Our ref: HMS ID 11558

## Advice on Modification Report – State Significant Development

**Proposal:** West Culburra Mixed Use Subdivision – Modification 1

**Major Project reference:** SSD-3846-Mod-1

Figure 1.3 - Proposed development works within the study area

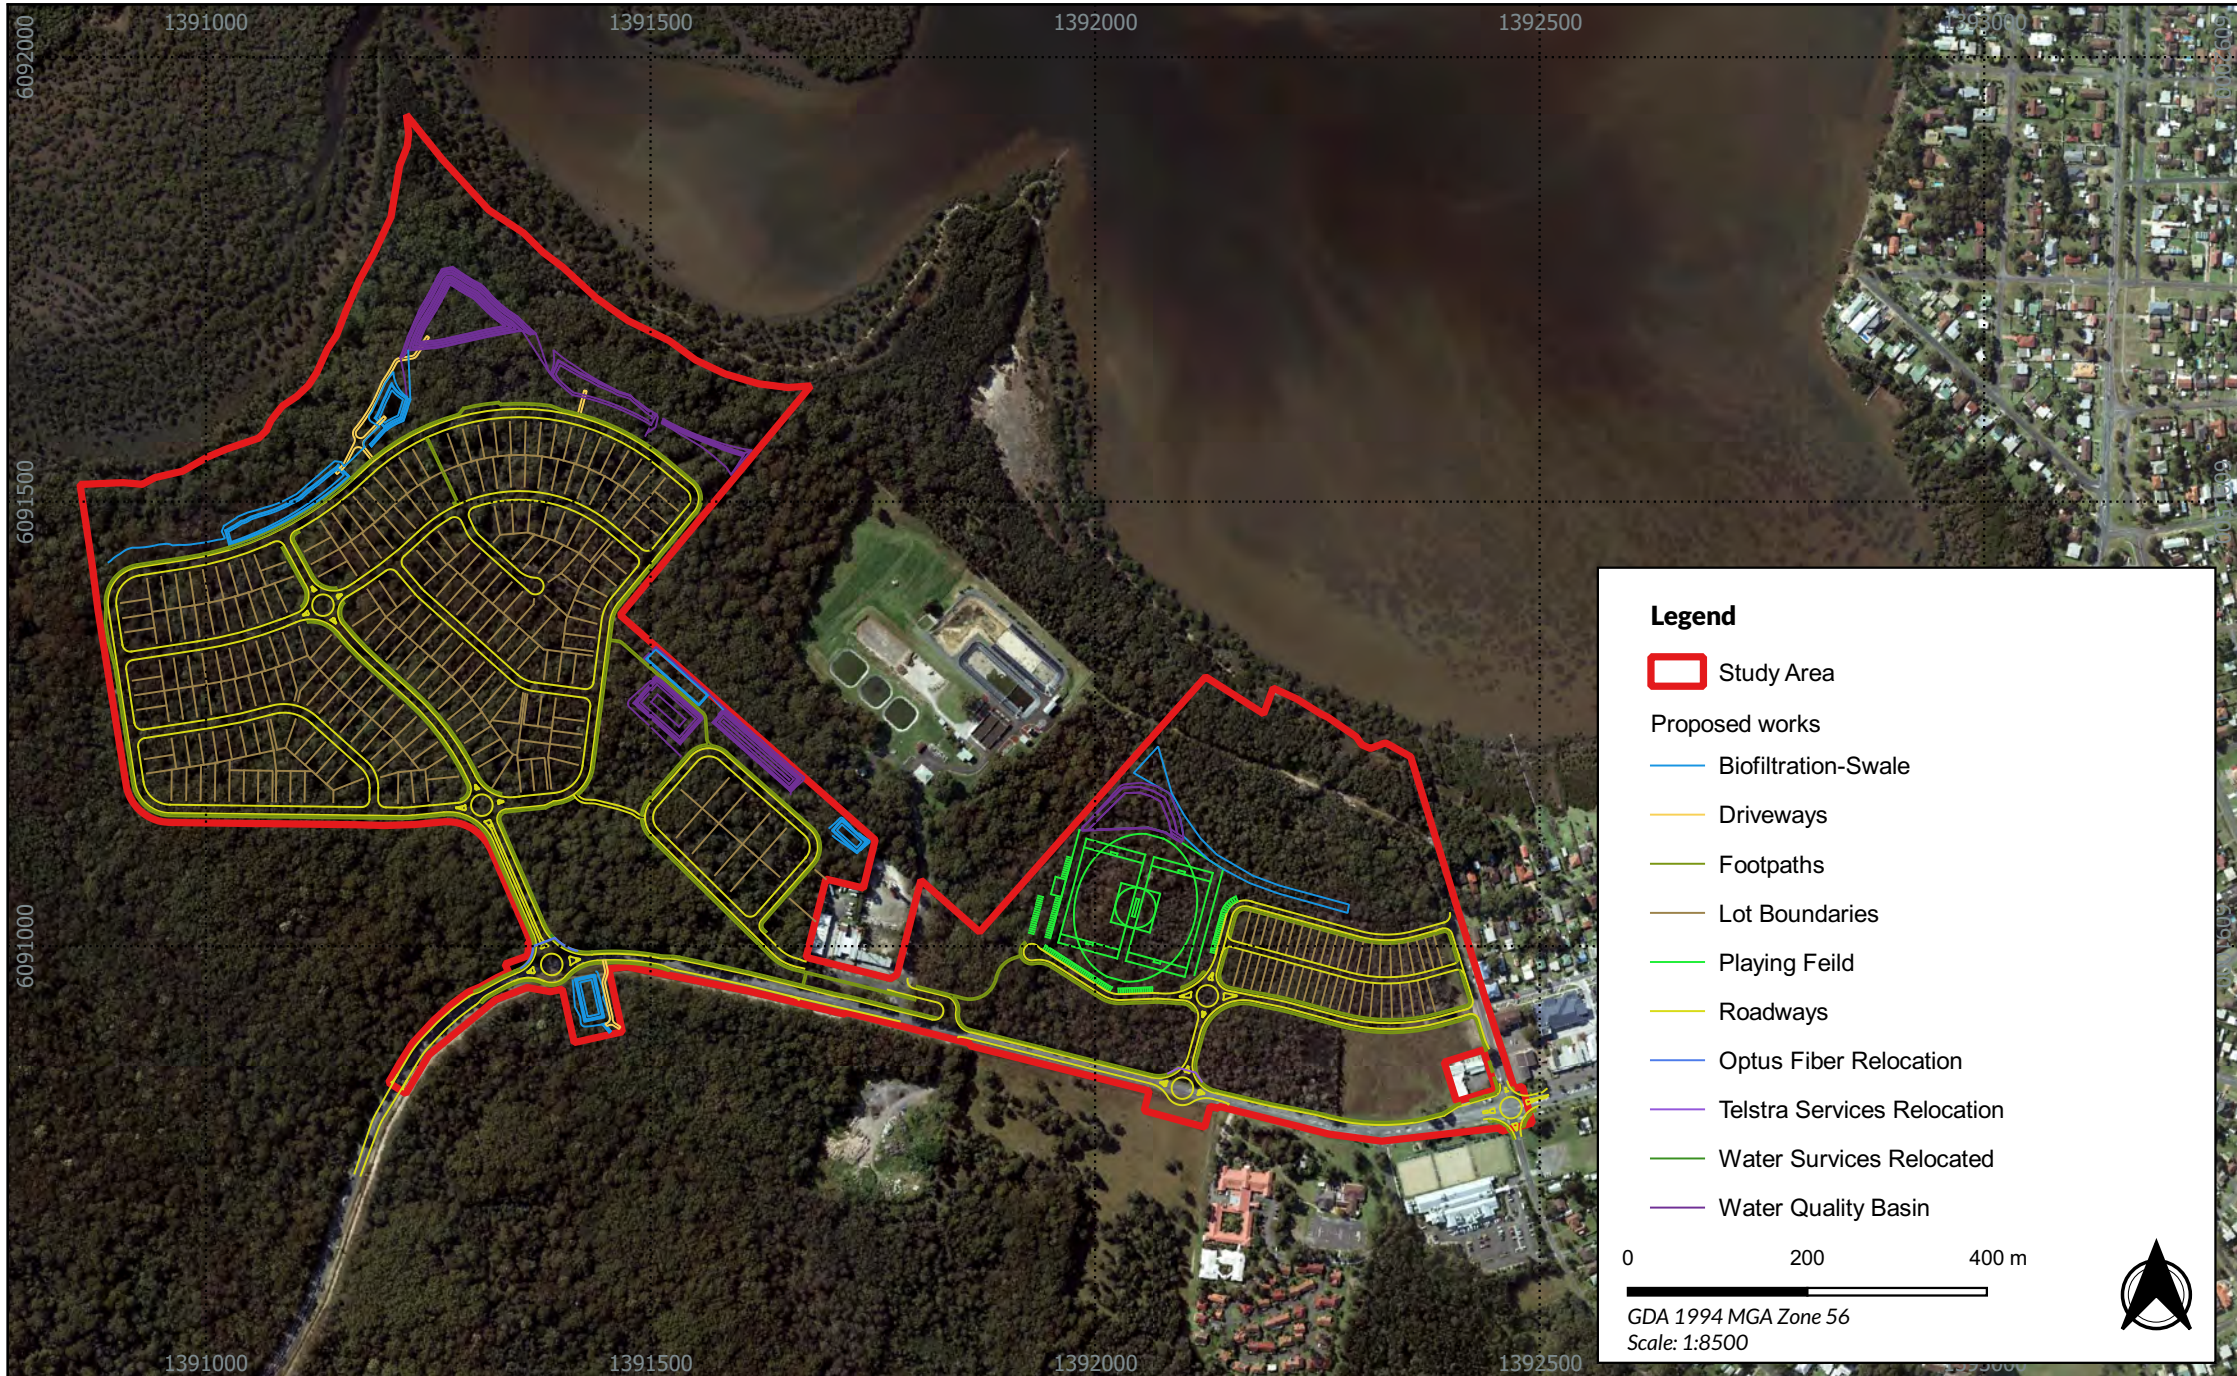
2. Please clarify whether the proposed changes as part of the current Modification application, including the re-orientation of the development footprint, will result in any changes to the proposed impacts to and/or management requirements for Aboriginal cultural heritage compared to those assessed as part of the original concept approval.
